# City of Portland, Maine - Building or Use Permit Application

<b>PERMIT ISSUED</b>		Permit No: 02-0801	Issue Date: AUG 12 2002	CBL: 168 C002001
Location of Construction: 716 Washington Ave	Owner Name: Robinson John B	Owner Address: 21 Belmont		Phone: 775-6759
Business Name:	Contractor Name: Applicant	Contractor Address: Portland		Phone:
Lessee/Buyer's Name	Phone:	Permit Type: Alterations - Dwellings		Zone: <b>R-5</b>

Past Use: Single Family	Proposed Use: Single Family	Permit Fee: \$163.00	Cost of Work: \$20,000.00	CEO District: 2
Proposed Project Description: Demolish Existing Barn and Erect New 20' x 35' Barn		<b>FIRE DEPT:</b> <input type="checkbox"/> Approved <input type="checkbox"/> Denied <b>INSPECTION:</b> Use Group: <b>ACC</b> Type: <b>5B</b> <i>(WRB)</i> Signature: <i>[Signature]</i>		<b>PEDESTRIAN ACTIVITIES DISTRICT (P.A.D.)</b> Action: <input type="checkbox"/> Approved <input type="checkbox"/> Approved w/Conditions <input type="checkbox"/> Denied Signature: _____ Date: _____

SECOND FLOOR PLAN

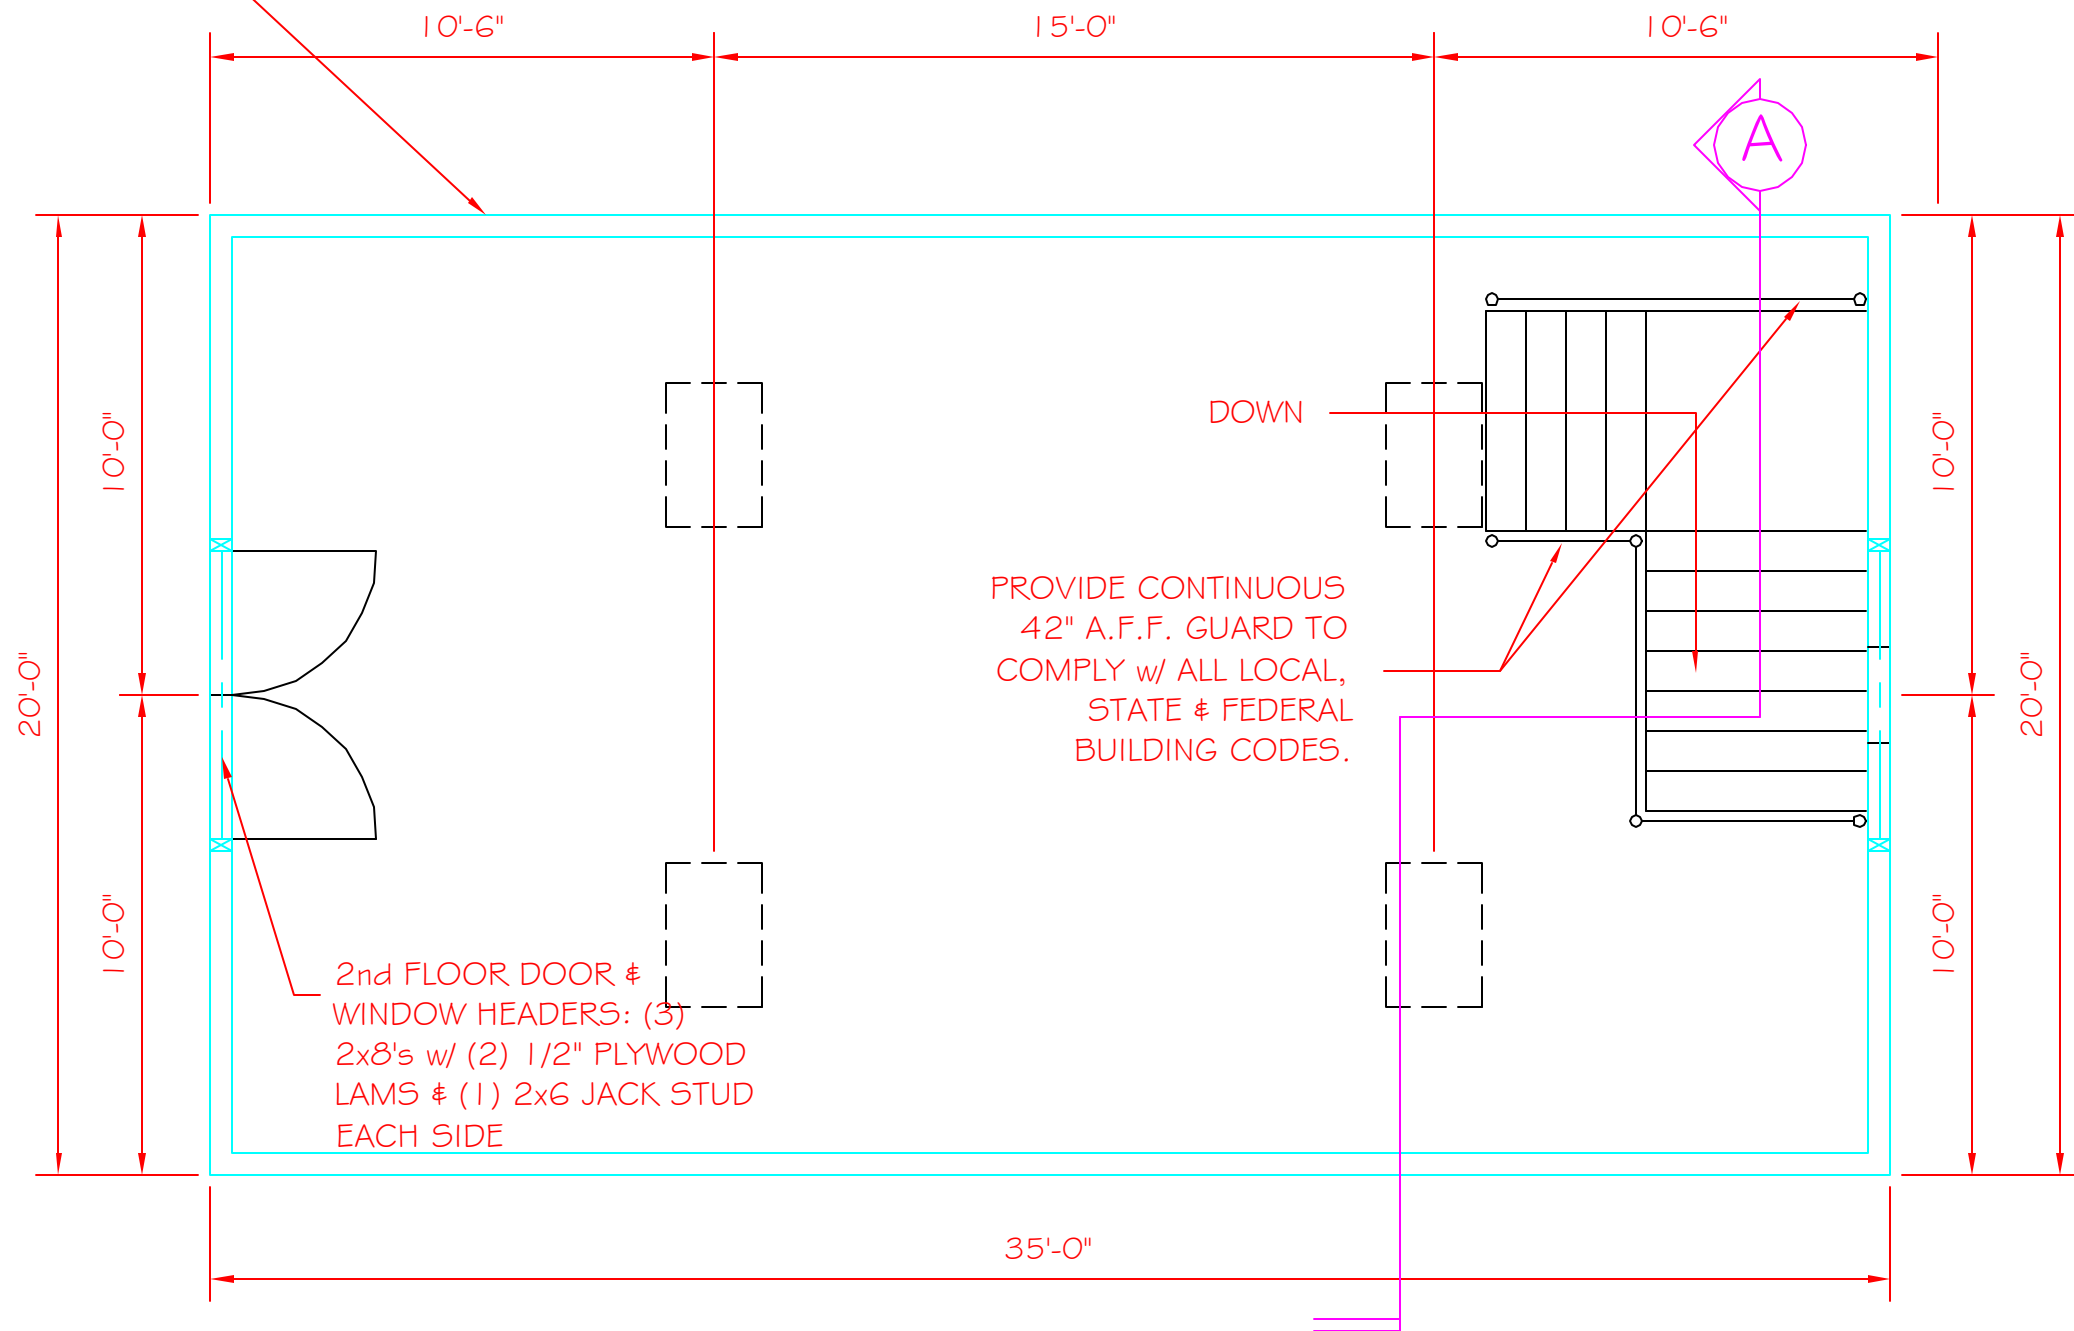
Guard rail must be installed around top of the stair opening and in front of the second floor double door. As per plan.

Comment Date	Comment	Add	Delete	Save
08/02/2002	How is this to be used???? Residential Only			
	Name	mjn	Follow Up Date	
				Completed
08/02/2002	How is the second floor double doors being protected? 36" guard with openings less than 4 in			
	Name	mjn	Follow Up Date	
				Completed
08/07/2002	Need Header Details, Fire separation assembly if less than 5 feet from property line and no op What floor option??			
	Name	mjn	Follow Up Date	
				Completed
